Department of Transportation

June 26, 2024

RE: Multi-Family Development - Fishers Canyon (P274)

The Traffic Impact Study dated July 3, 2023 by Kimley-Horn has been reviewed by a CDOT Traffic Engineer. Their comments are as follows:

FIGURE 6
VENETUCCI THOMPSON THRIFT
EL PASO COUNTY, COLORADO
PROJECT TRIP DISTRIBUTION

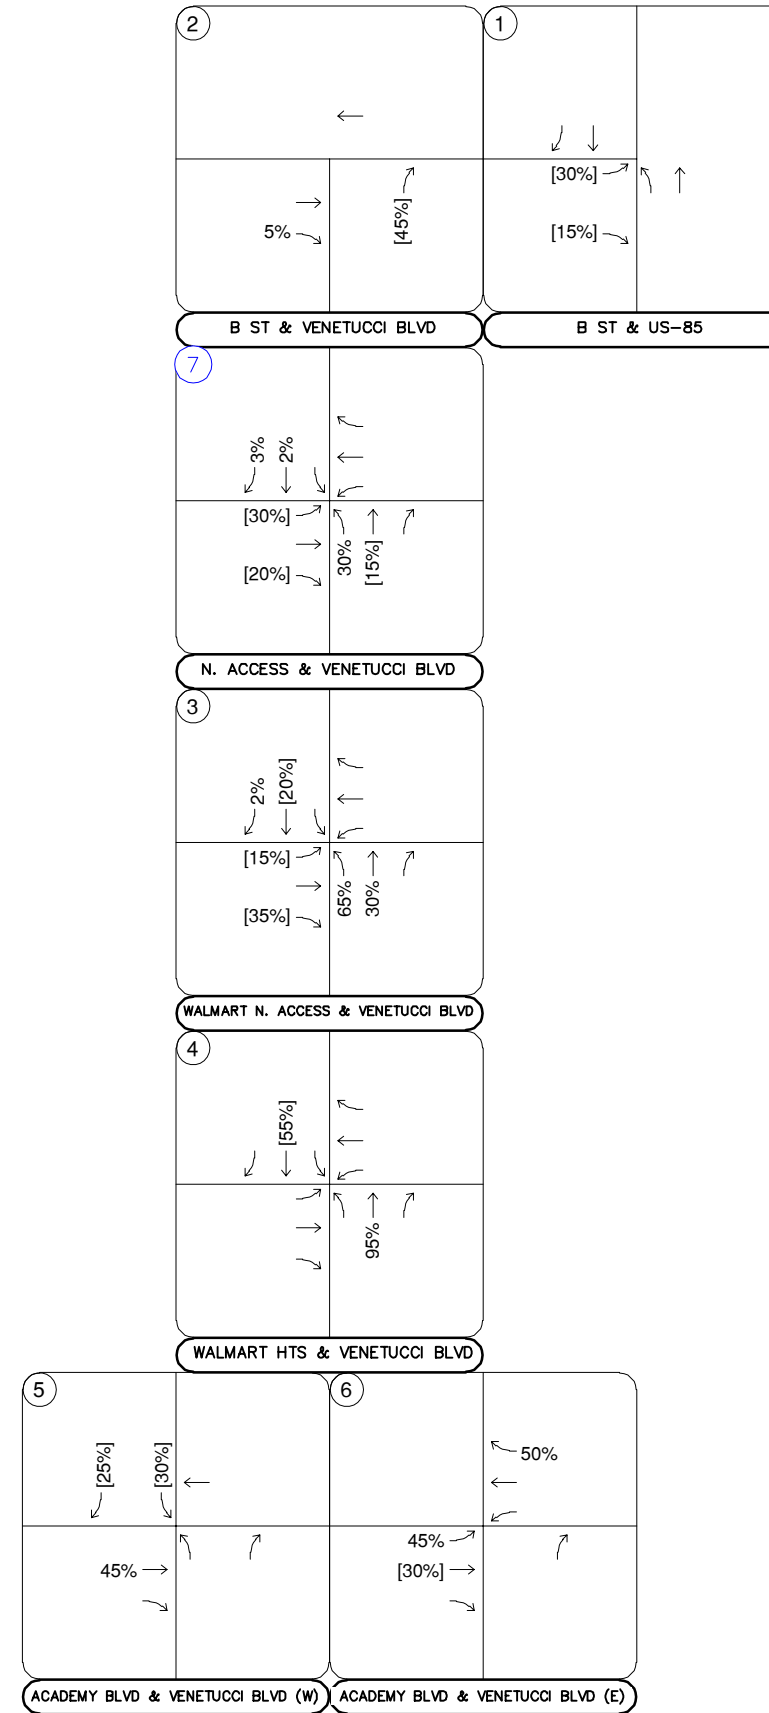
- Addressed** • Distribution (Figure 6): Traffic using B St is underestimated considering the existing AADT. Assume 10% entering/exiting trips West of intersection #2 and 15% North, and 15% East of intersection #1. The remaining 60% of entering/exiting trips would be from/to South through Academy Blvd. Use this distribution for both AM and PM peaks.
- Addressed** • Traffic Signal Timings: Use the attached timings for the existing conditions. Optimization is allowed for future scenarios, but clearance intervals should remain the same as in the existing conditions. Attached are the signal timings for US-85 & B St.
- Addressed** • Update the analysis and resubmit the study.
- Acknowledged** • In regard to the T-intersections exhibit as submitted CDOT will withhold comments at this time due to changes requested in the comments above that may change the configuration.
